**Response to Submissions
Mosman High School Upgrade
SSD 10465**

This document is provided by Woods Bagot, the architects for the project, as a response to the relevant submissions provided by DPIE, for the Mosman High School Upgrade State Significant Development Application.

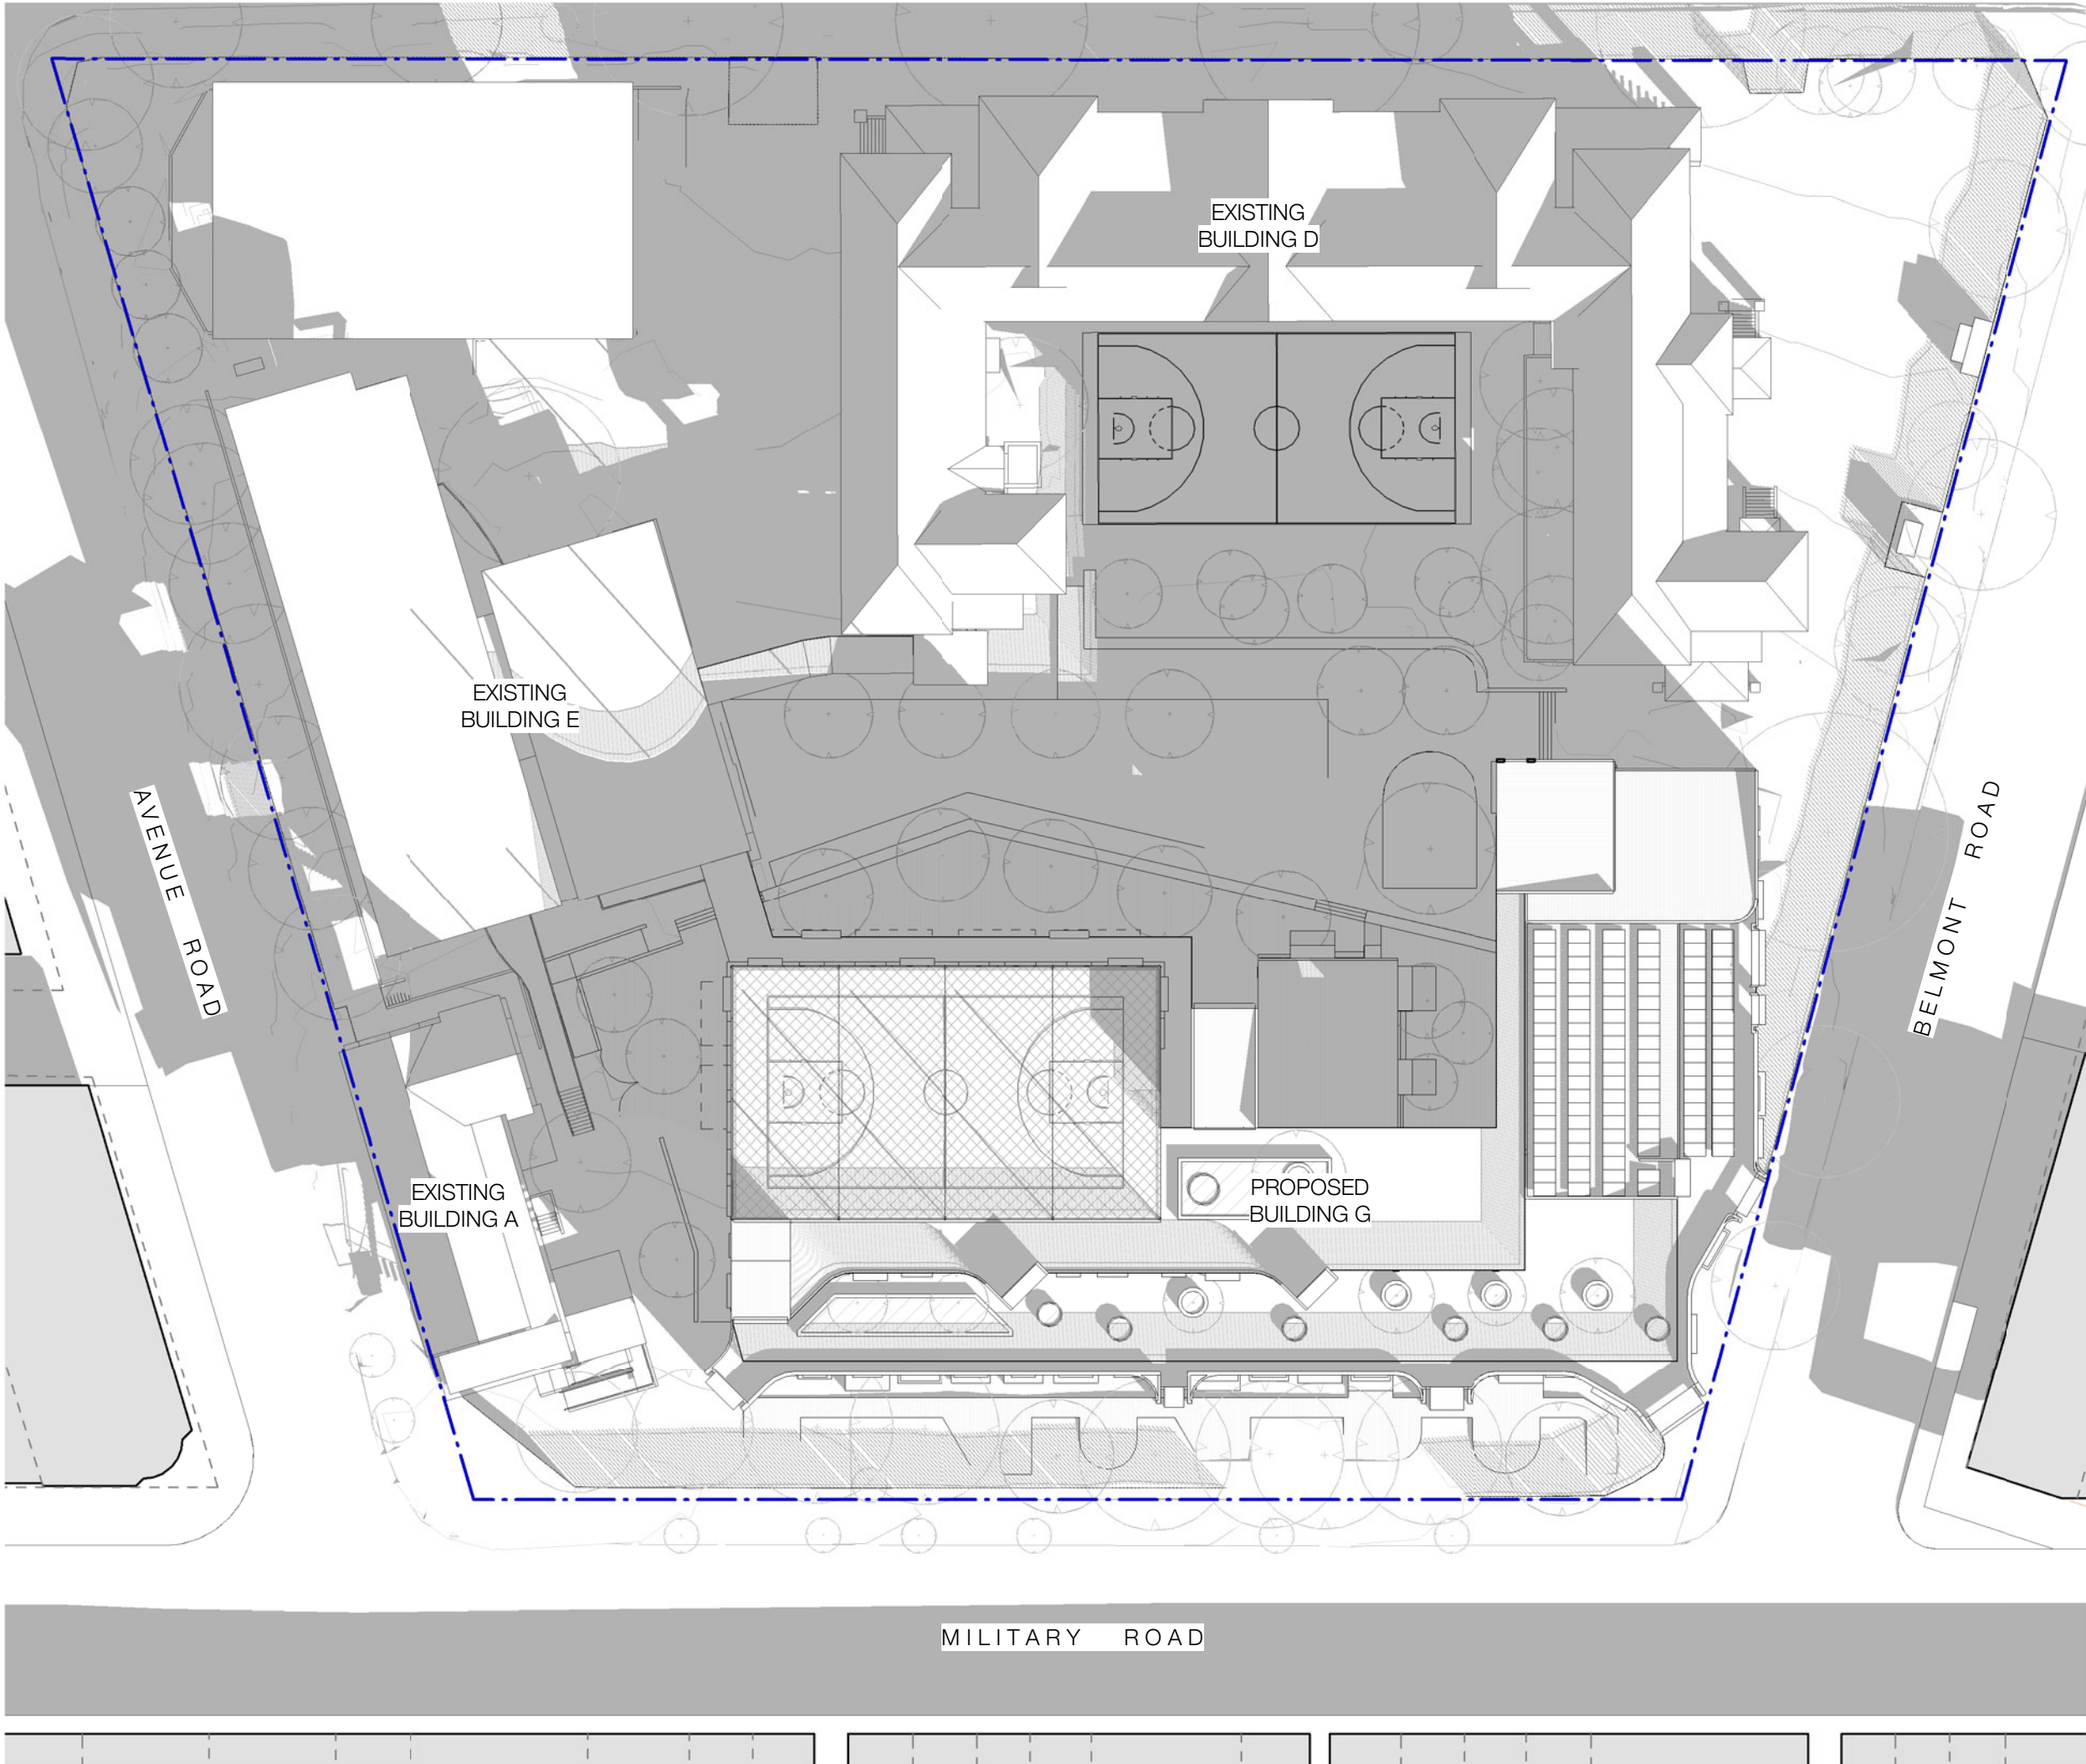
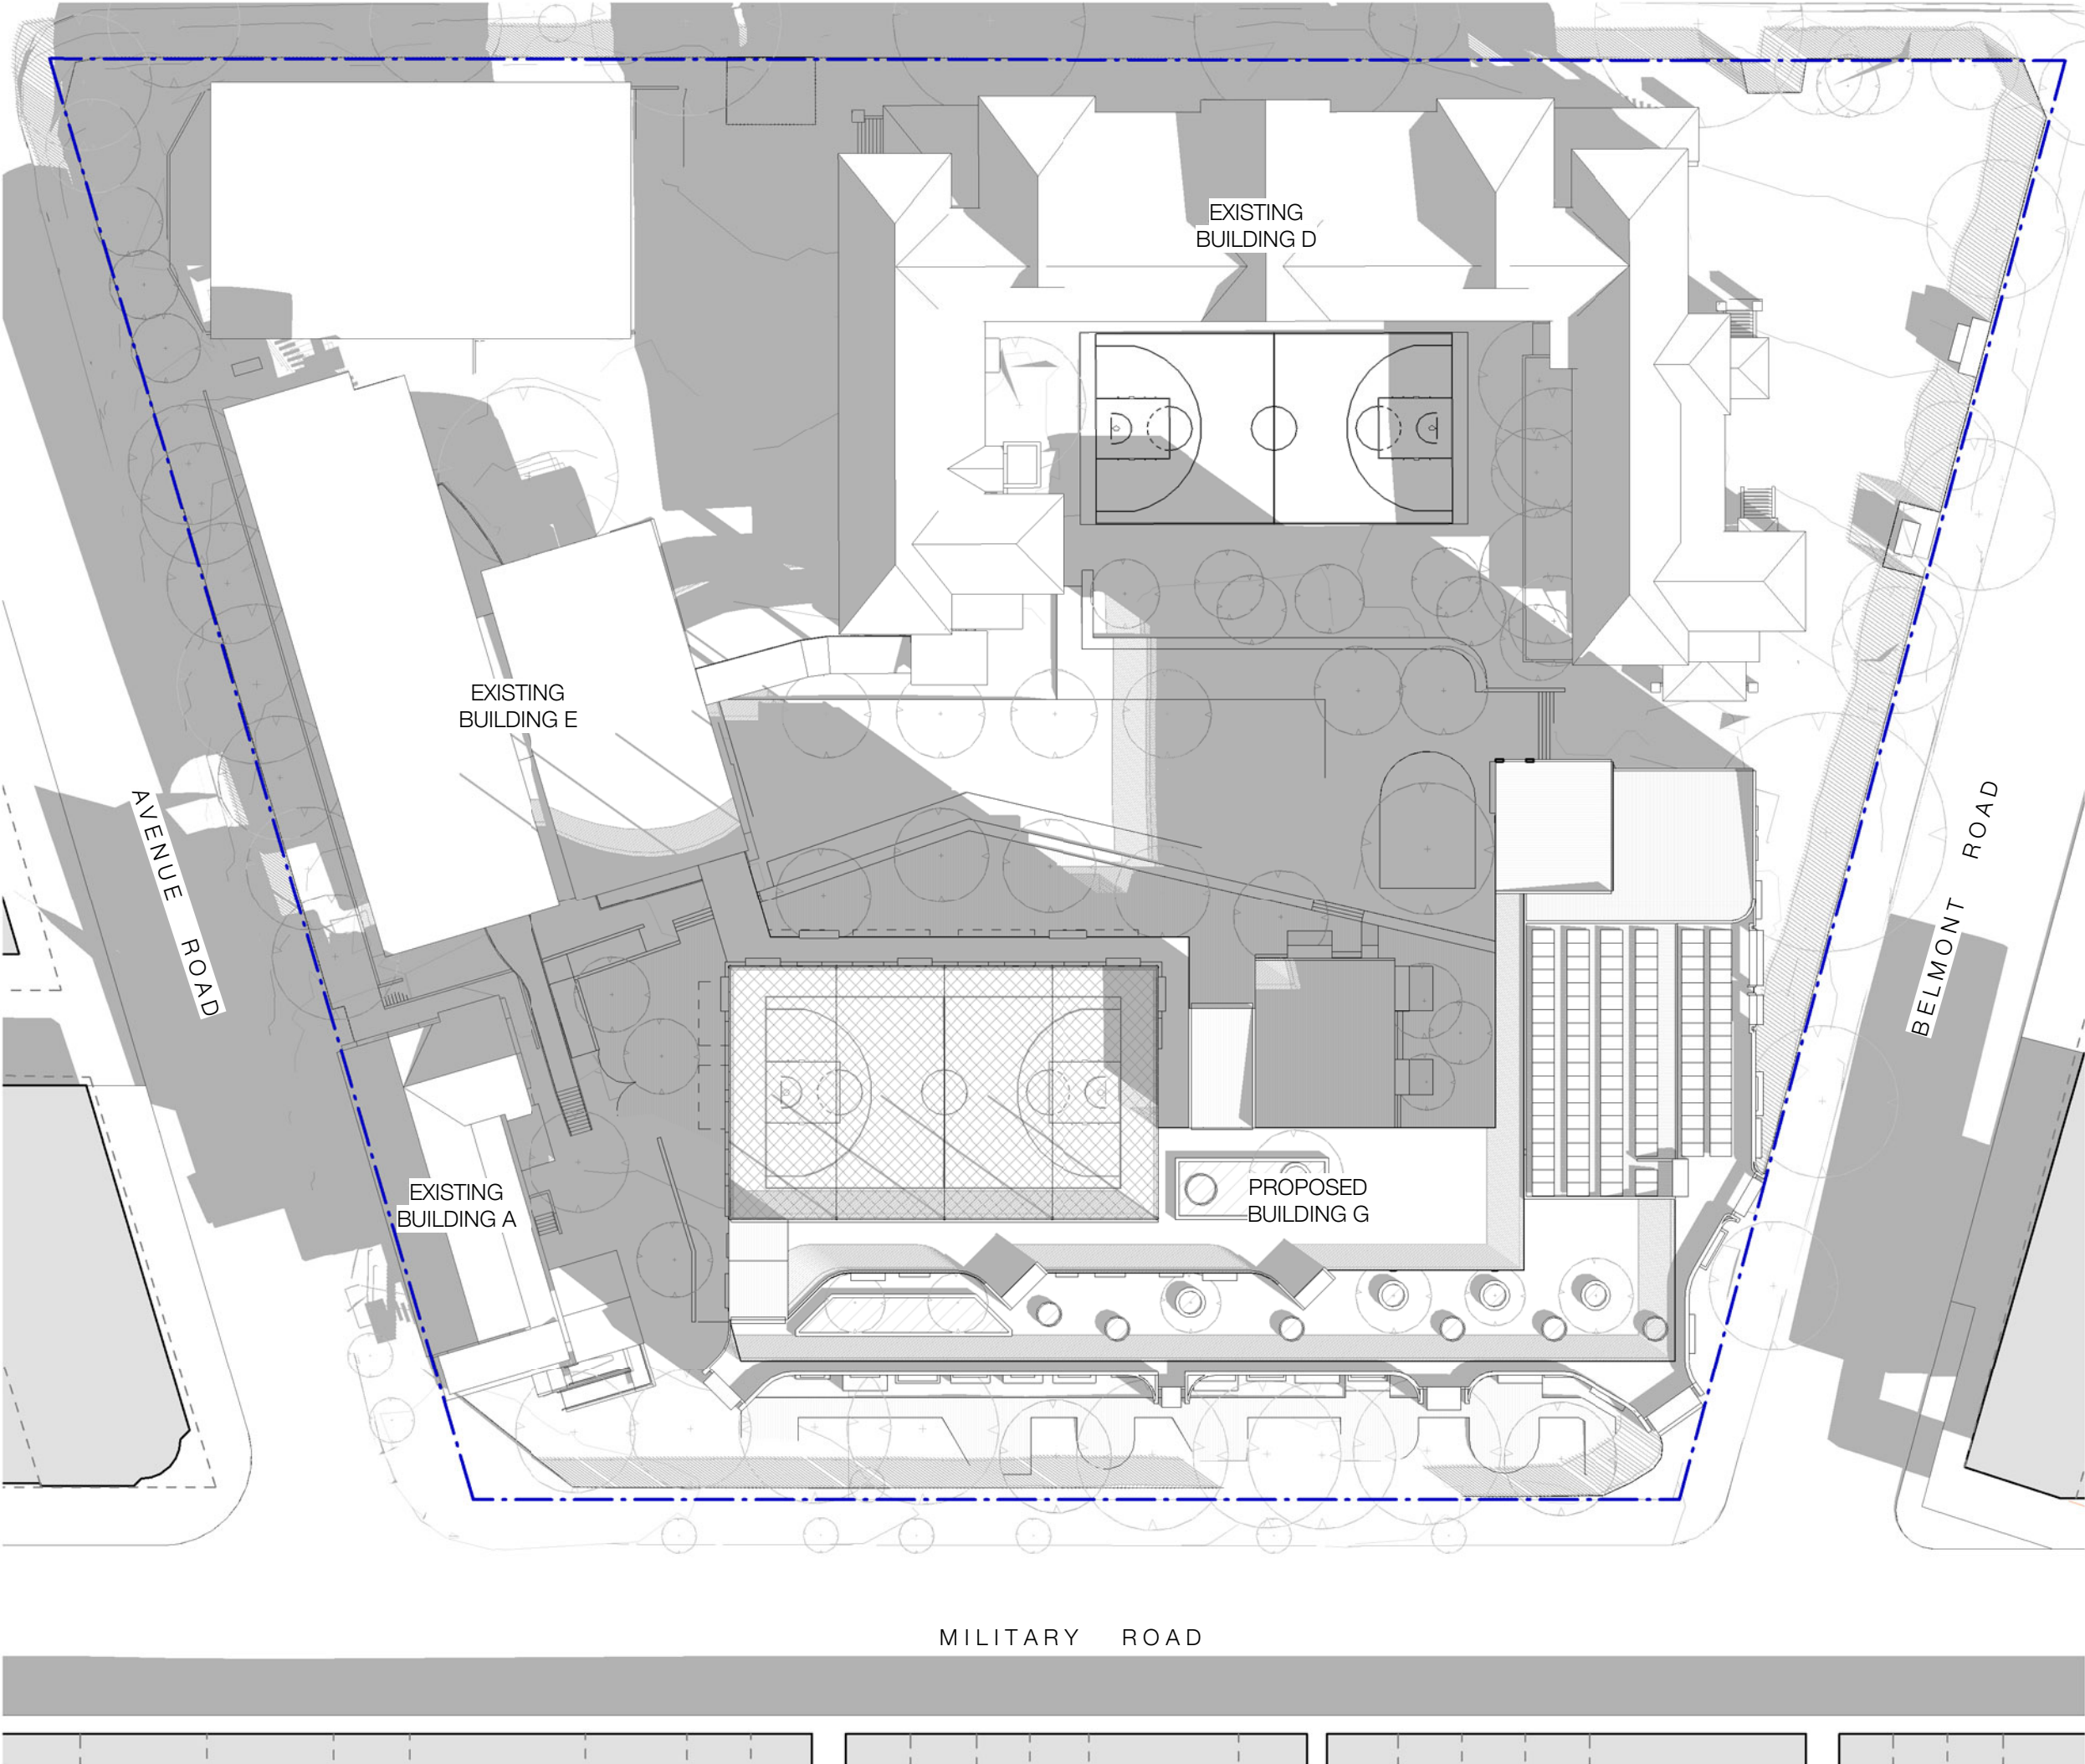
We note that plans submitted for public comment are only PRELIMINARY. This is unacceptable as they are technically incomplete and do not reflect the actual site complete shadow diagrams. Evidenced by the missing presentation of FULL SHADOW DIAGRAMS on impacted (Morning) Belmont Road, Keston Avenue & Avenue Road e.g. South West corner 6:00am(Summer) to 7:30am(Winter). Let's be honest – Easterly morning sun shine is critical to our neighbours amenity. (Afternoon) – Military Road retail shopping strip (Winter) 3:00 - 5:00pm. Let's keep the retail street sunny and a great place to shop.

Shadow diagrams are enlarged to capture the extend of Belmont Road, Avenue Road and Gladstone Avenue. There are no further shadowing impacts to Keston Avenue from Proposed building G from 9am to 3pm, winter and summer solstice.
